Application No: BR/213/21/HH
Site Address: 12-14 The Steyne Bognor Regis PO21 1TP
Description of works: Erection of front porch extension, installation of first floor double balcony and external facade alterations (This application may affect the character and appearance of The Steyne, Bognor Conservation Area)

Thank you for your internet representation made on 30th October 2021 which has been recorded as no objection with the comments as follows:

DRAWING: Front Facade Alterations			
TITLE: Proposed Plans and Elevations			
SCALE AT A1: 1 : 50	DATE: Issue Date	DRAWN: EL	CHECKED: AP
PROJECT NO: The Styn	DRAWING NO: WLD-010-21-05	REVISION:

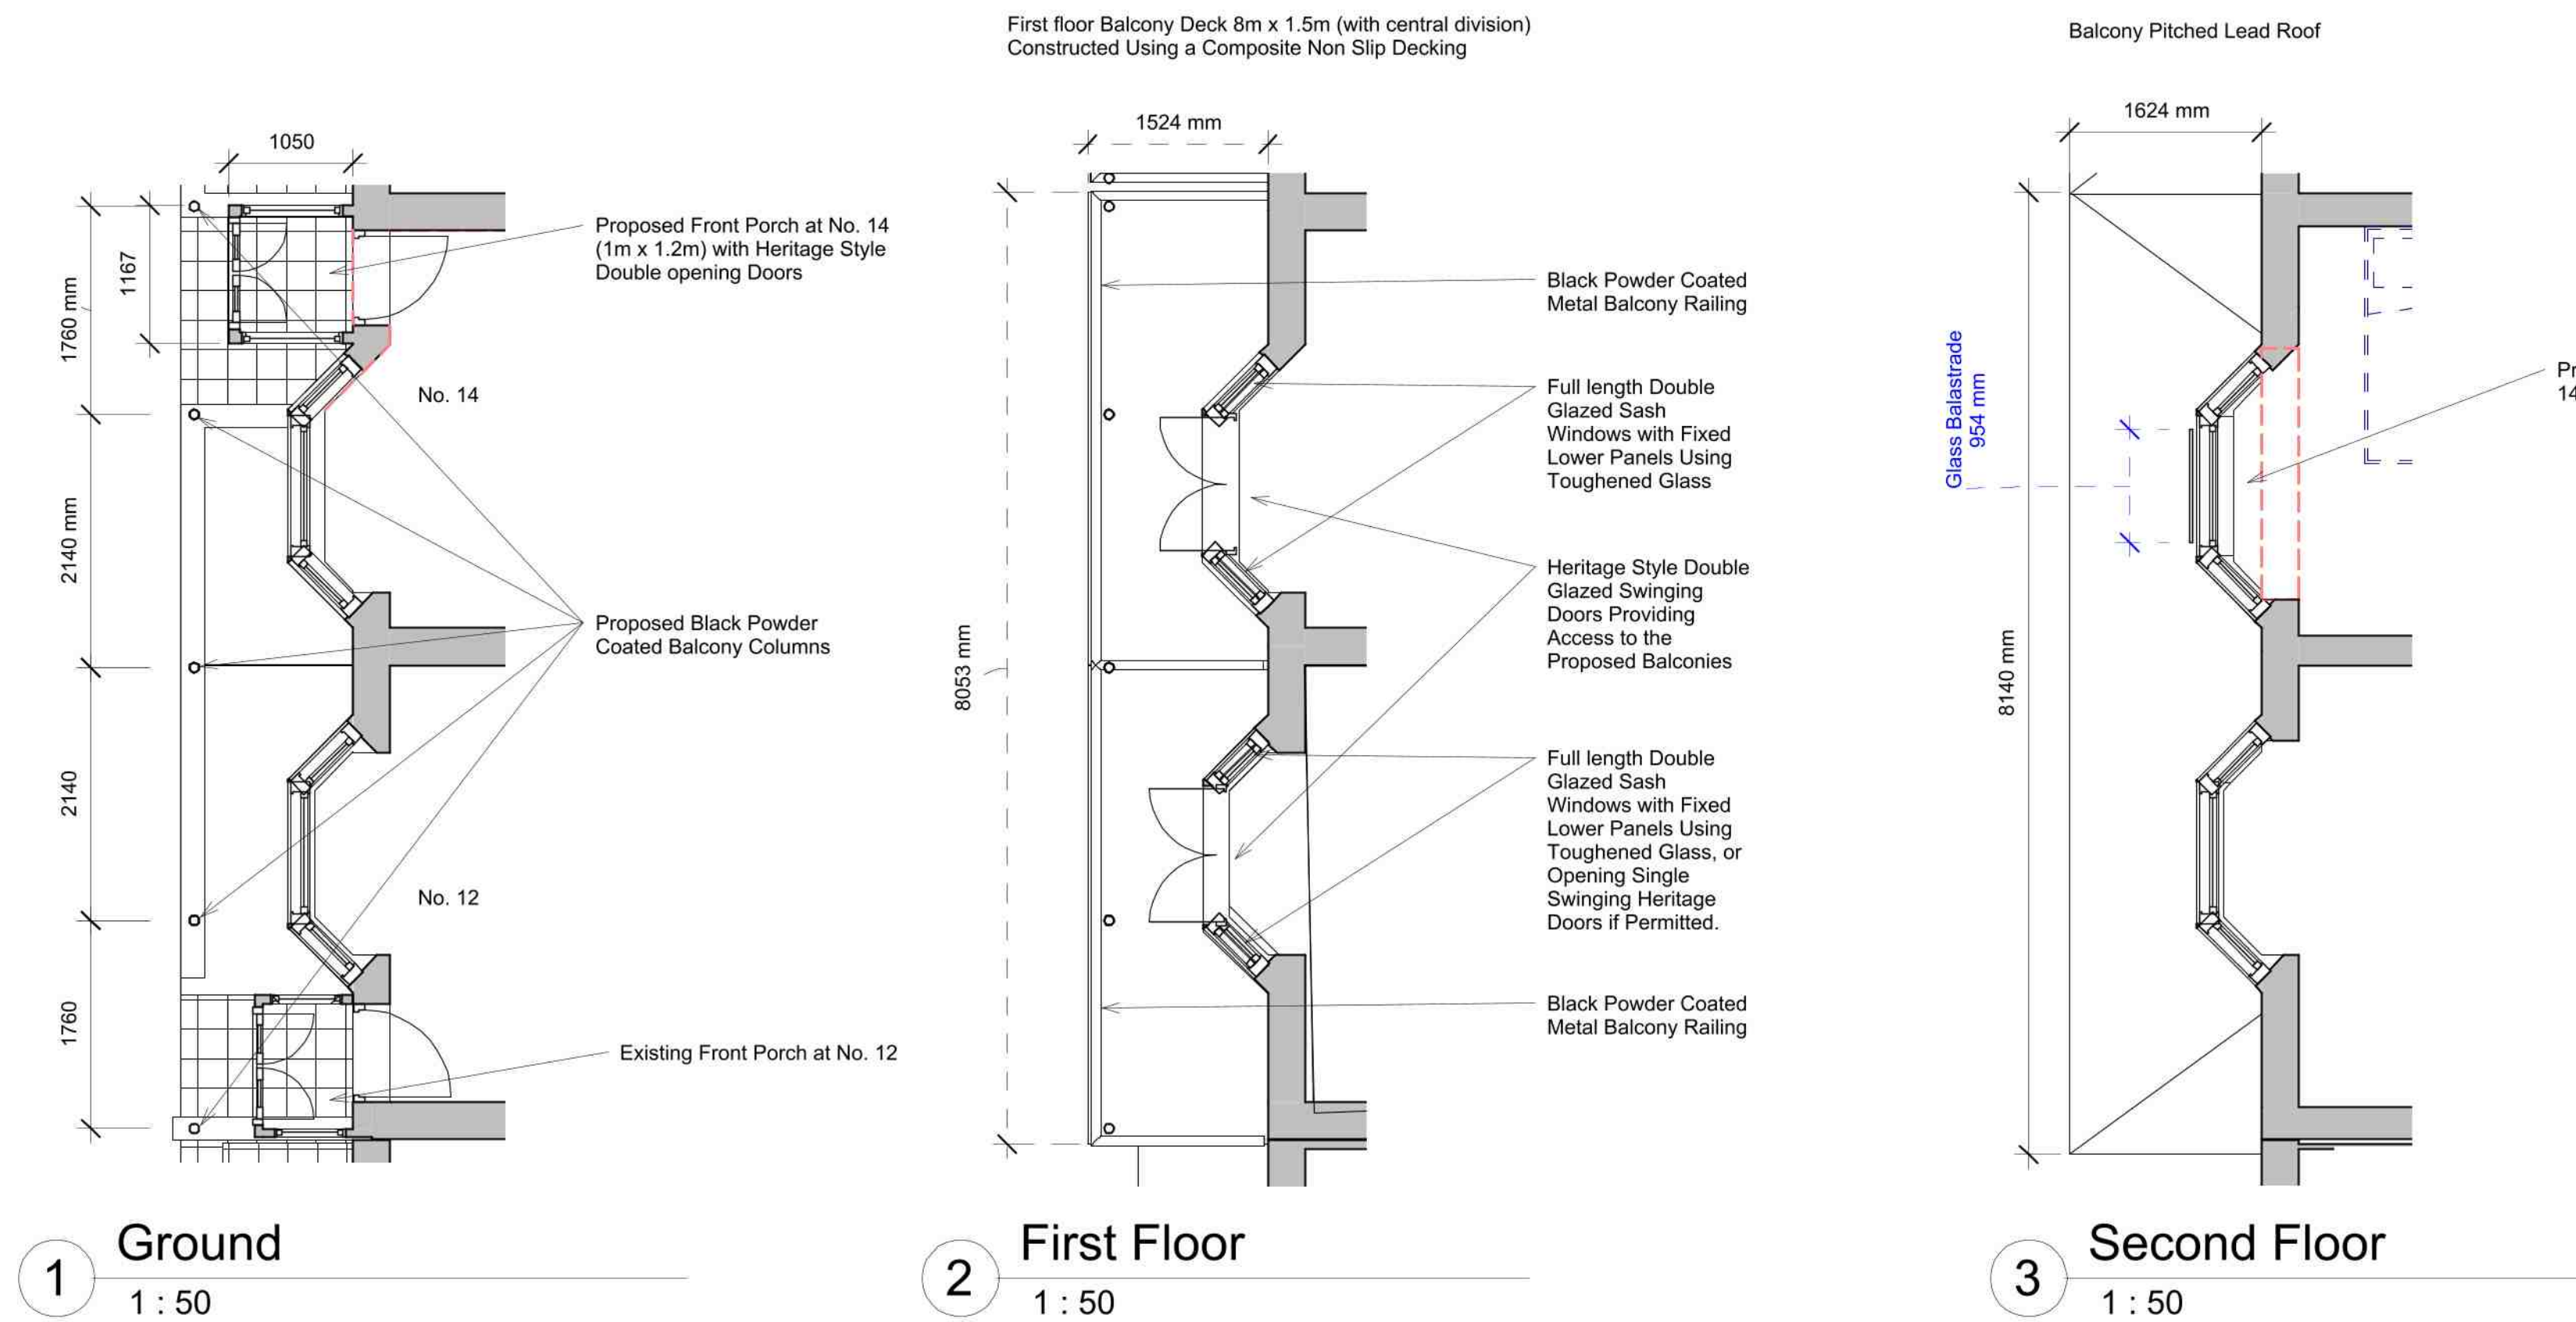
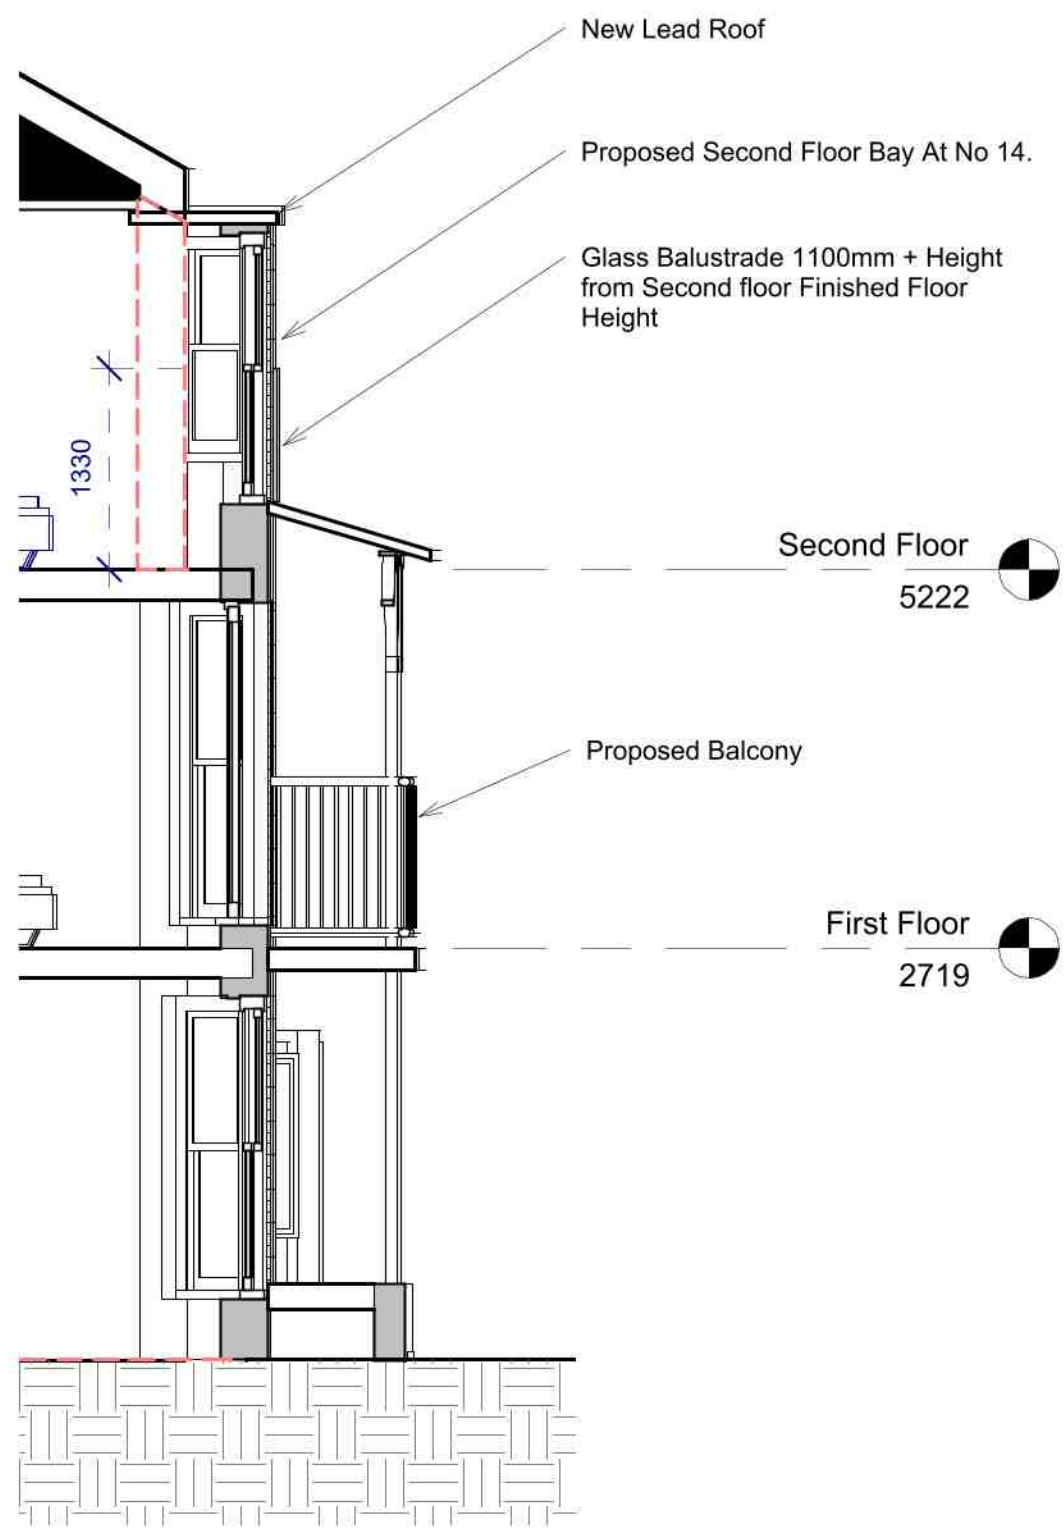
The Panel would have preferred to see the complete removal of the two front porches since they are not appropriate to the period and architectural style of the buildings and they crowd the attractive angled bays. An original rendered doorway hood still survives at no 12 which could have been replicated at no 14 and then with the provision of two painted timber six panel doors recessed in the original doorway openings a considerable visual improvement would have been made to the two properties.

It is suggested that, given the location in the historic core of the conservation area, all new windows and doors should be of painted timber and the windows are vertically sliding sashes.

The proposed front balconies are welcomed features and will complement the existing ones in the street scene.
